**Re: Daycare Center**  
**515 Old Coors Dr.**  
**Traffic Circulation Layout**  
Architect's Stamp 11-21-16 (K11-D086)

Based upon the information provided in your submittal received 11-21-16, the above referenced plan cannot be approved for Building Permit until the following comments are addressed:

SHEET
TCL
1 of 1

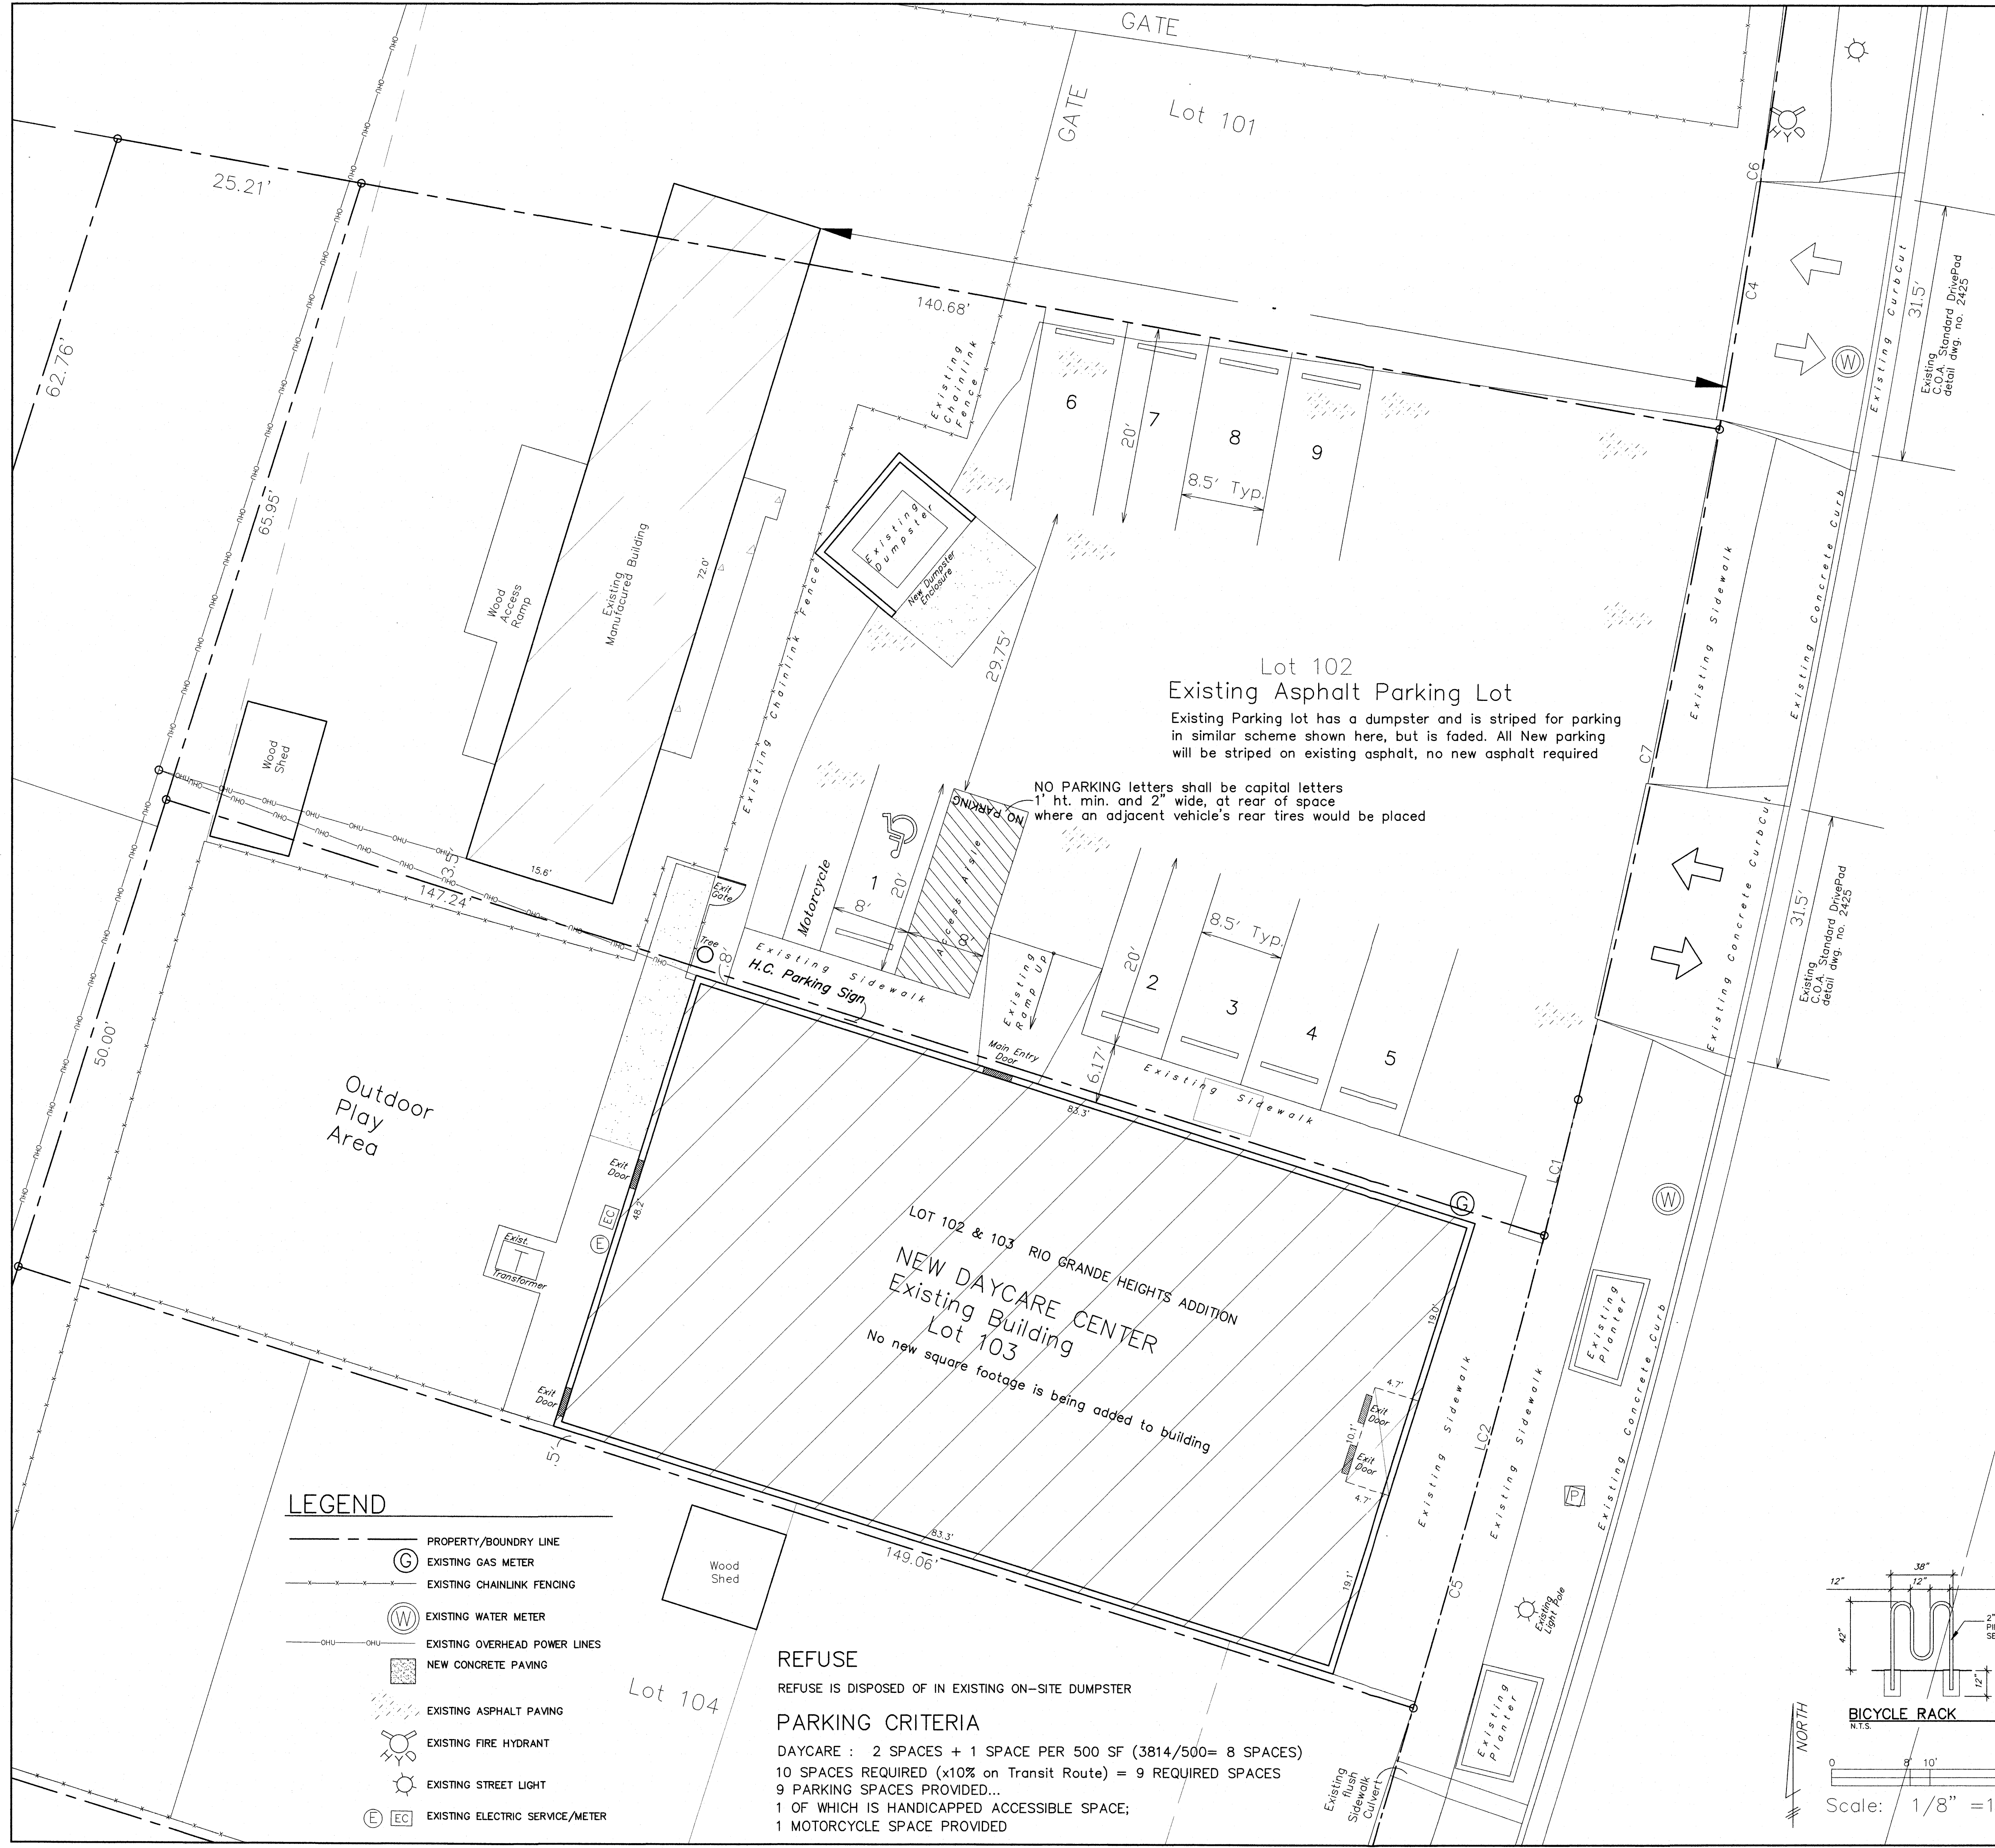
1. The handicap accessible spaces must include an access aisle. Van accessible aisles should be 8ft wide; all others should be 5ft wide.
2. The ADA accessible parking sign must have the required language per 66-7-352.4C NMSA 1978 **"Violators Are Subject to a Fine and/or Towing."** Please call out detail and location of HC signs.
3. The ADA access aisles shall have the words **"NO PARKING"** in capital letters, each of which shall be at least one foot high and at least two inches wide, placed at the rear of the parking space so as to be close to where an adjacent vehicle's rear tire would be placed. (66-1-4.1.B NMSA 1978)
